December 14, 2017

RE: Claremont Commercial Filing No.2, Preliminary Plan, SP-17-004 - 1st Review Response

This letter responds to your May 8, 2017 review letter relating to the above referenced project. Responses to review comments are shown in **red** below.

PRELIMINARY GRADING AND EROSION CONTROL PLAN

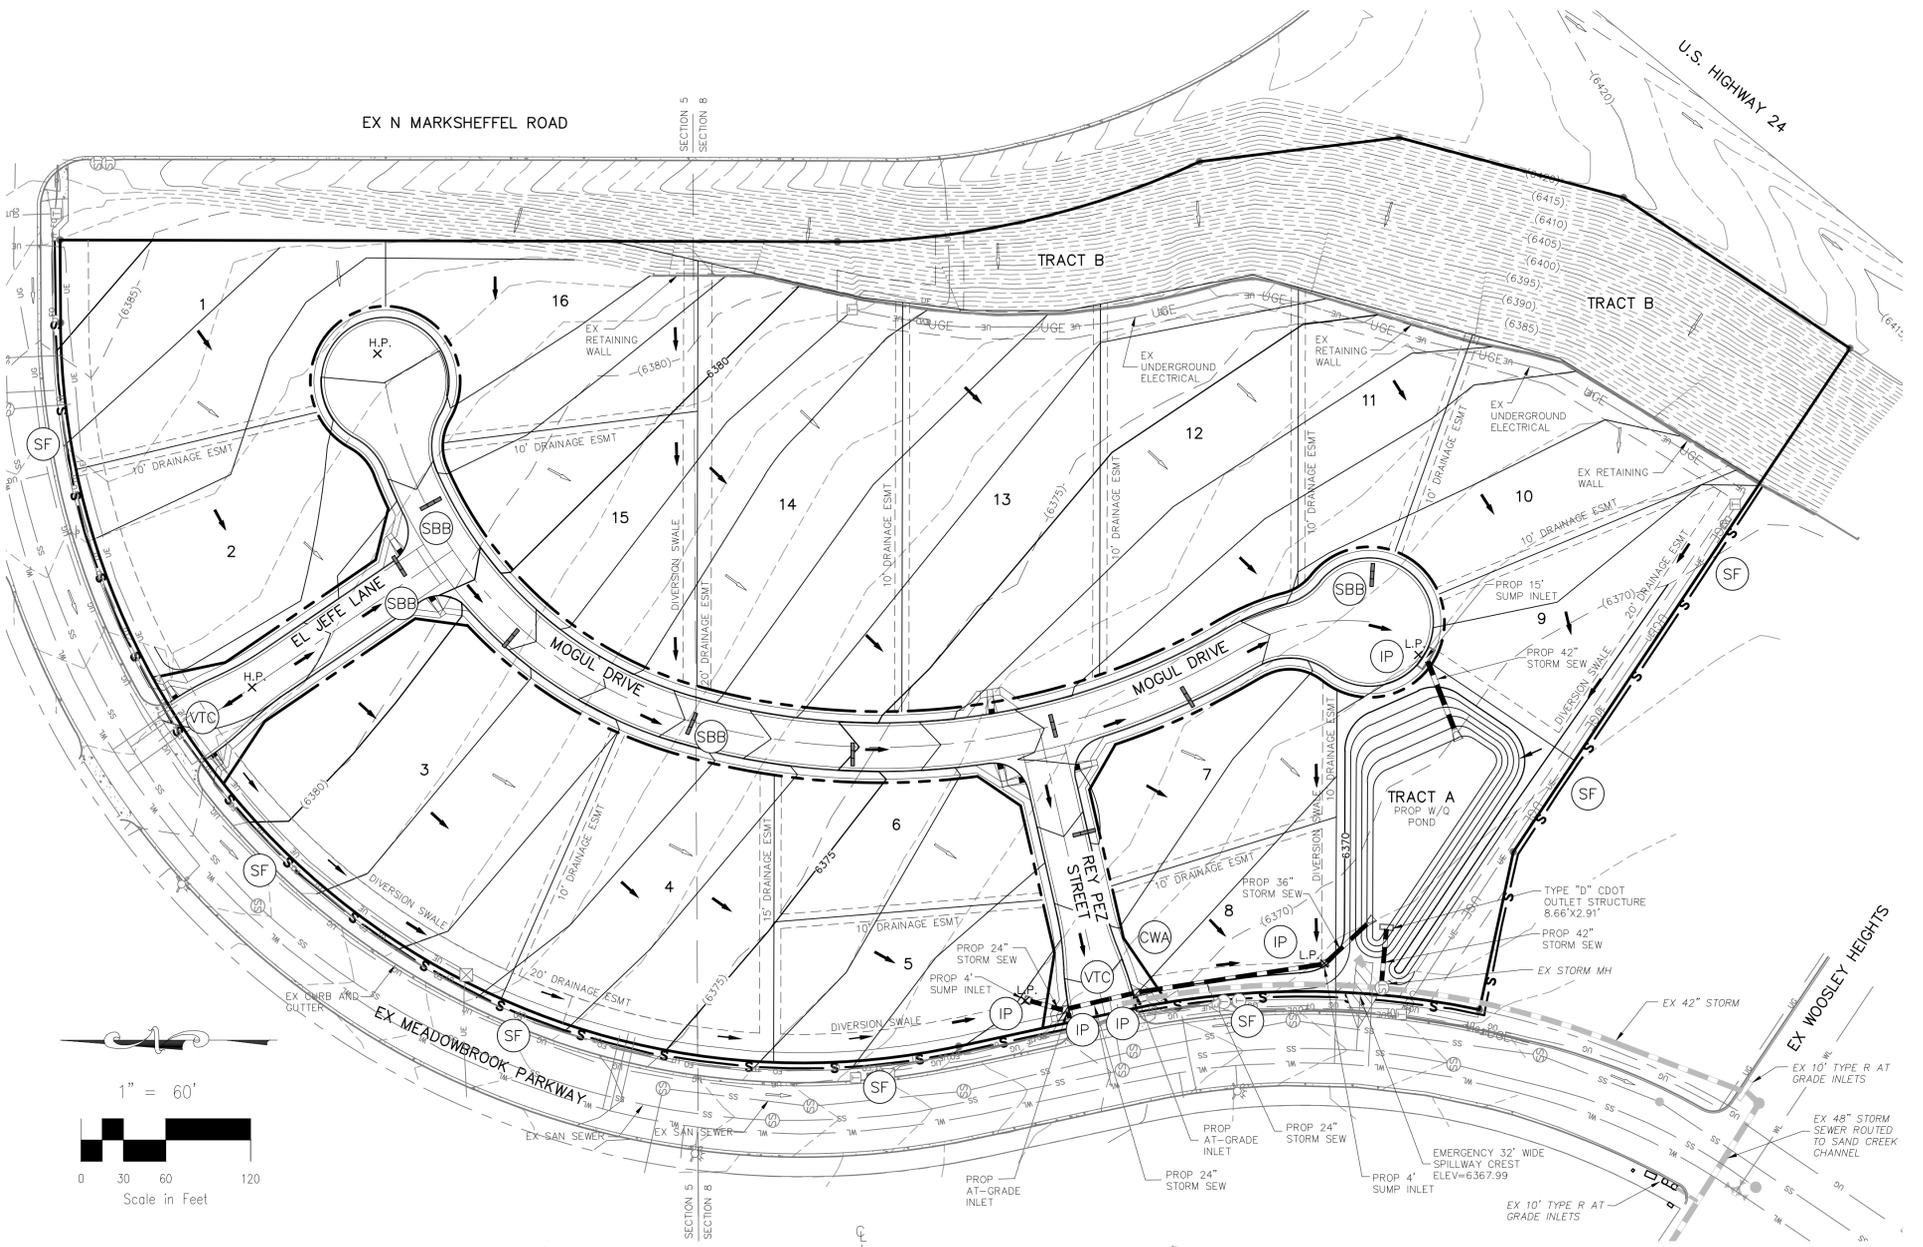
4. Ensure that all structures, to include retaining walls, are a minimum of 15ft away from existing utility lines. This may require adjustment of site grading. **Easements have been added and revisions to the pond have made to ensure that existing utilities are protected.**
